June 2, 2017

City of Albuquerque
Planning Department
Current Planning Section

Re: Environmental Planning Commission
Project#: 1011188, case #17EPC-40007 May 11 – Site Development Plan for Building Permit

0 5' 10' 20'
1/8" = 1'-0"

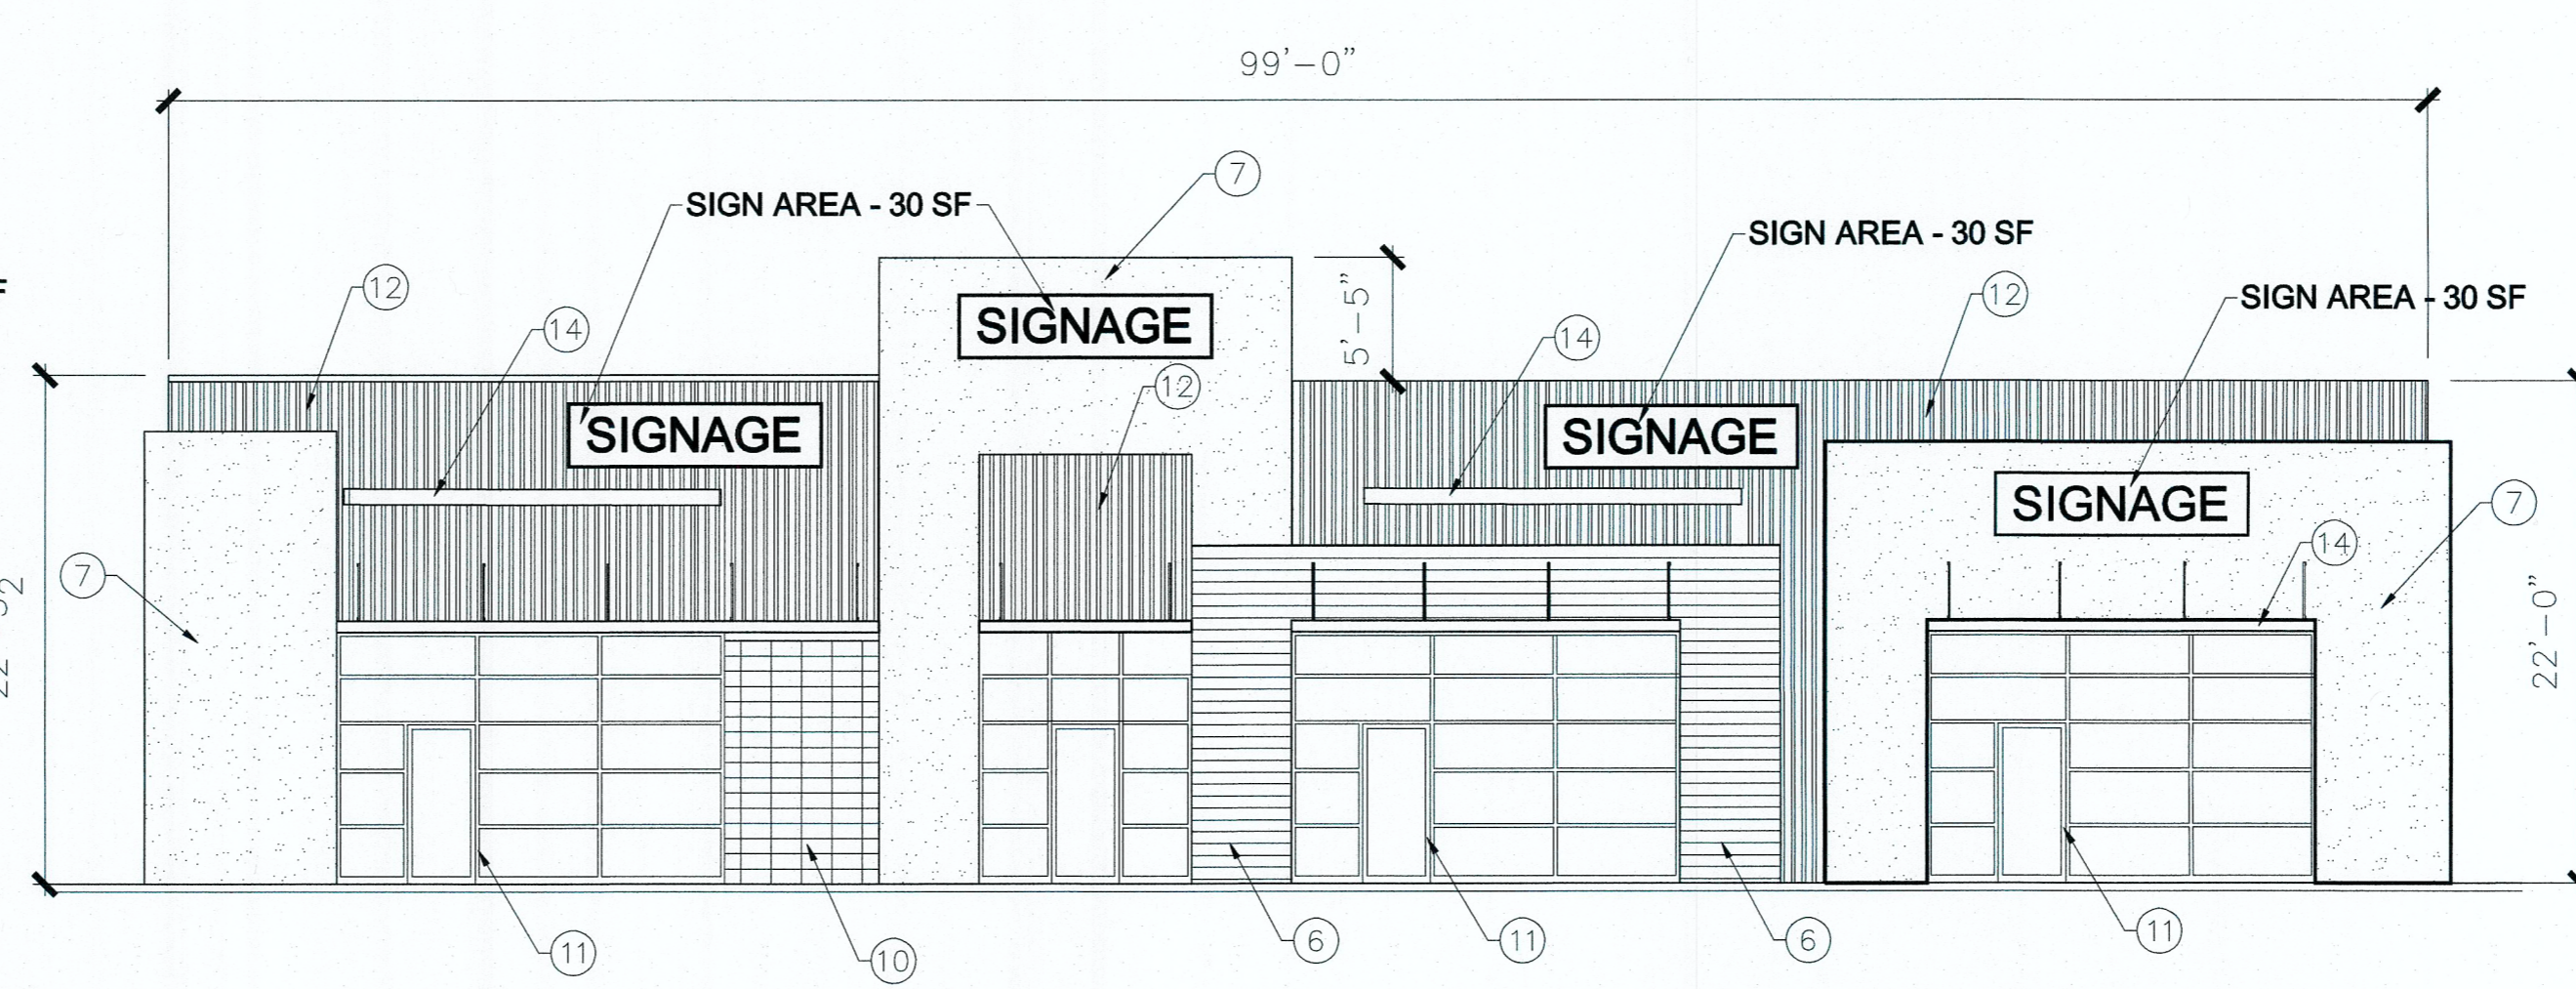
Comment Number 5: General note “B” has been added to sheet A3 to address future signage.
